Mrs Young
Rossida
Stonefields
Rustington
BN16 3BY

Please ask for: Nicola Moore
Email: nicola.moore@arun.gov.uk
Telephone: Ext 37944
Our Ref: R/278/21/CLP
Your Ref:
Date: 11th November 2021

Lawful Development Certificate for a Proposed Use or Development

Development: Lawful development certificate for the proposed removal of existing rear projection & conservatory and erection of a single store flat roof extension to full width of rear elevation.
Location: Rossida Stonefields Rustington BN16 3BY

FOR MR & MRS YOUNG		
SITE 'ROSSIDA', STONEFIELDS, RUSTINGTON. BN16 3BY		
TITLE EXTENSION & ALTERATIONS PROPOSED FLOOR PLAN		
SCALE 1:50 @ A3	DRAWN AH 08/21	DRAWING NO. 07 REV A

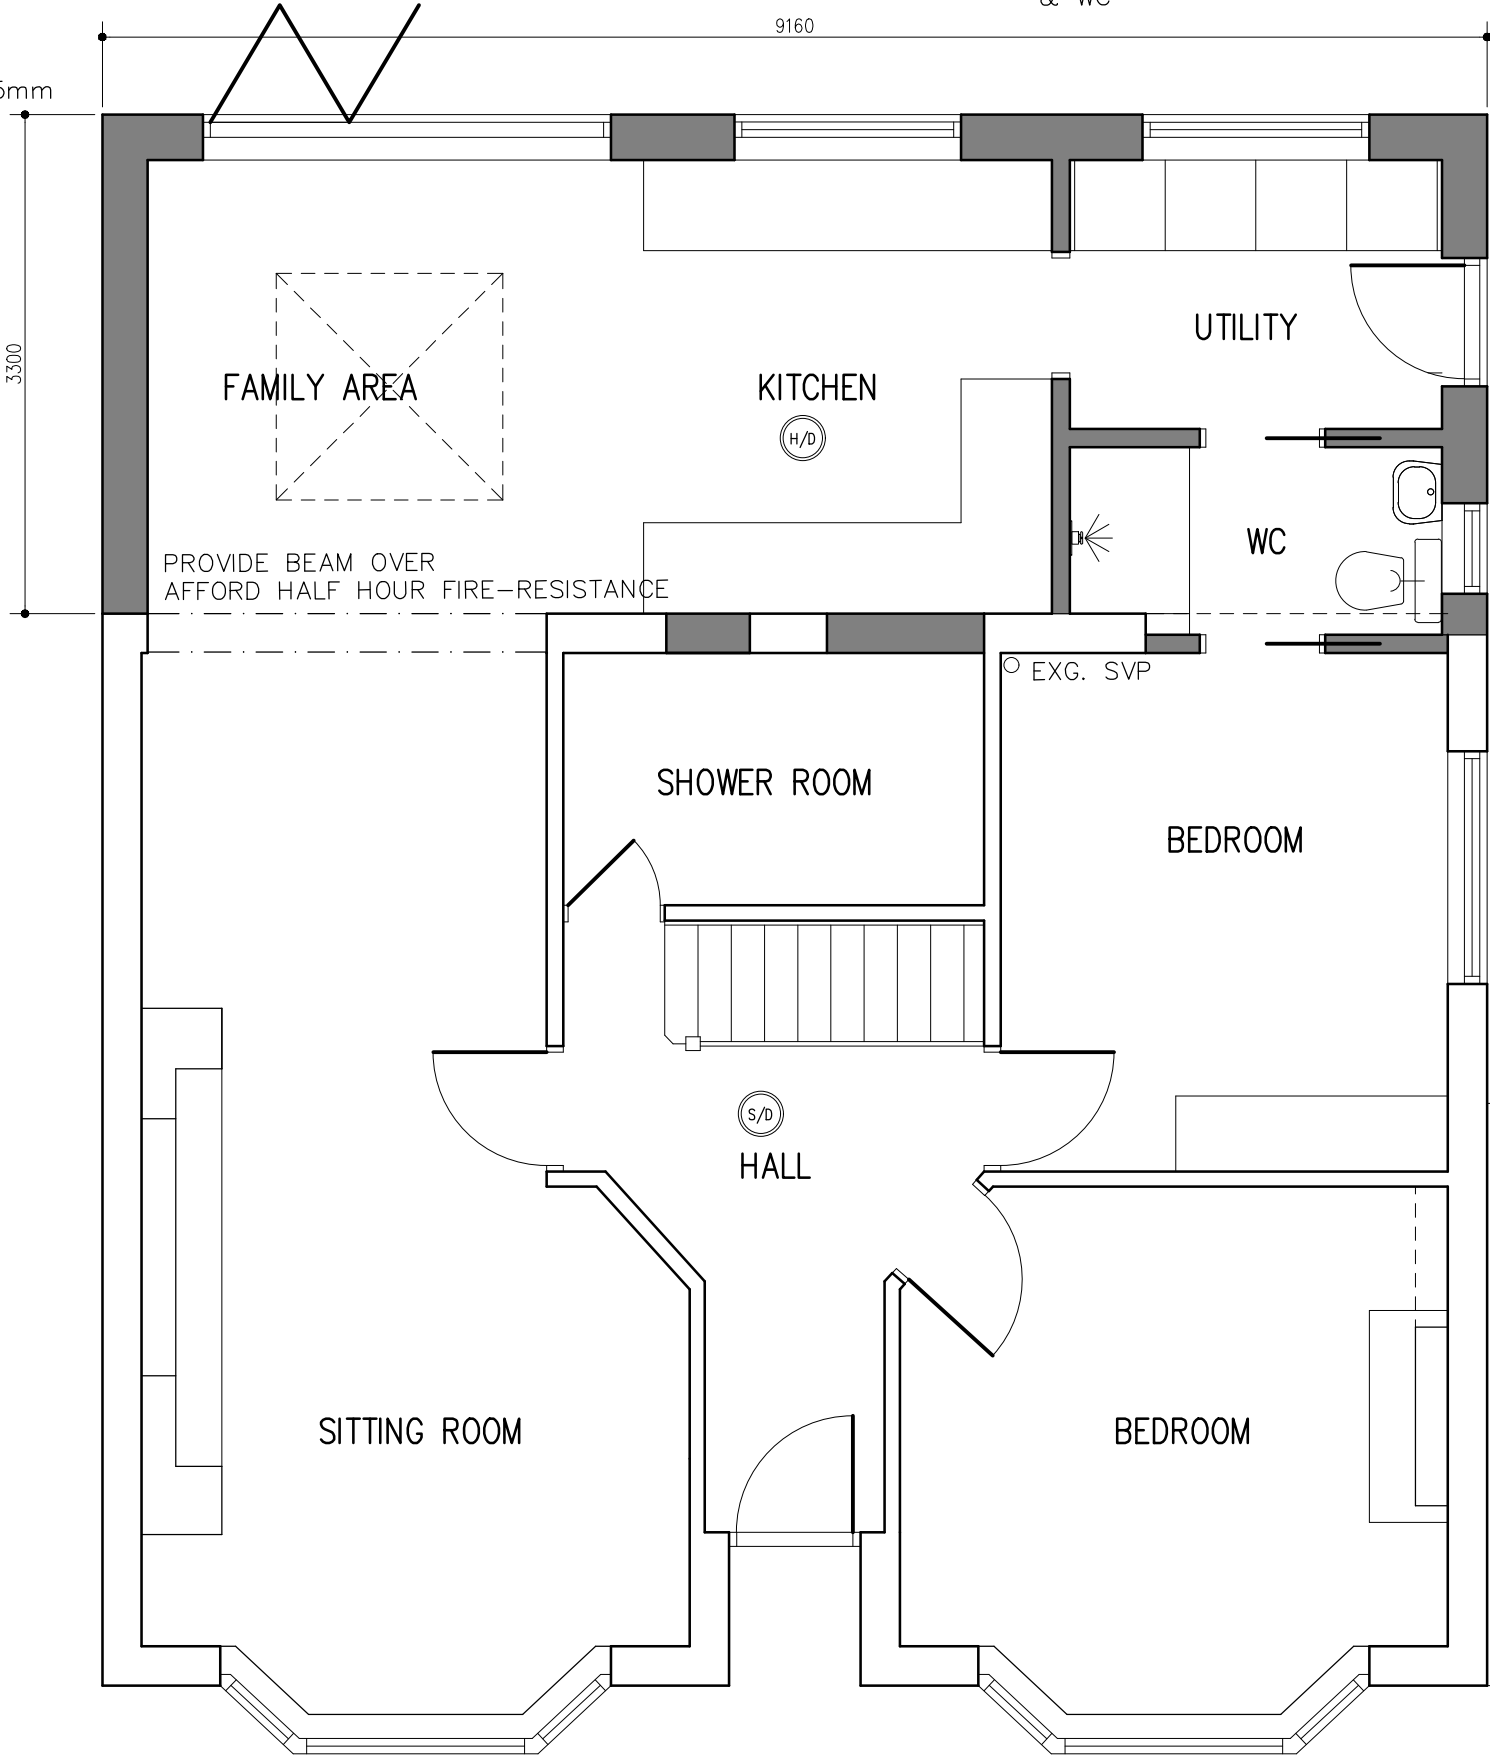
The Proposed Floor Plans (Dwg No 04) does not scale correctly at 1:50. Please amend accordingly and re submit.
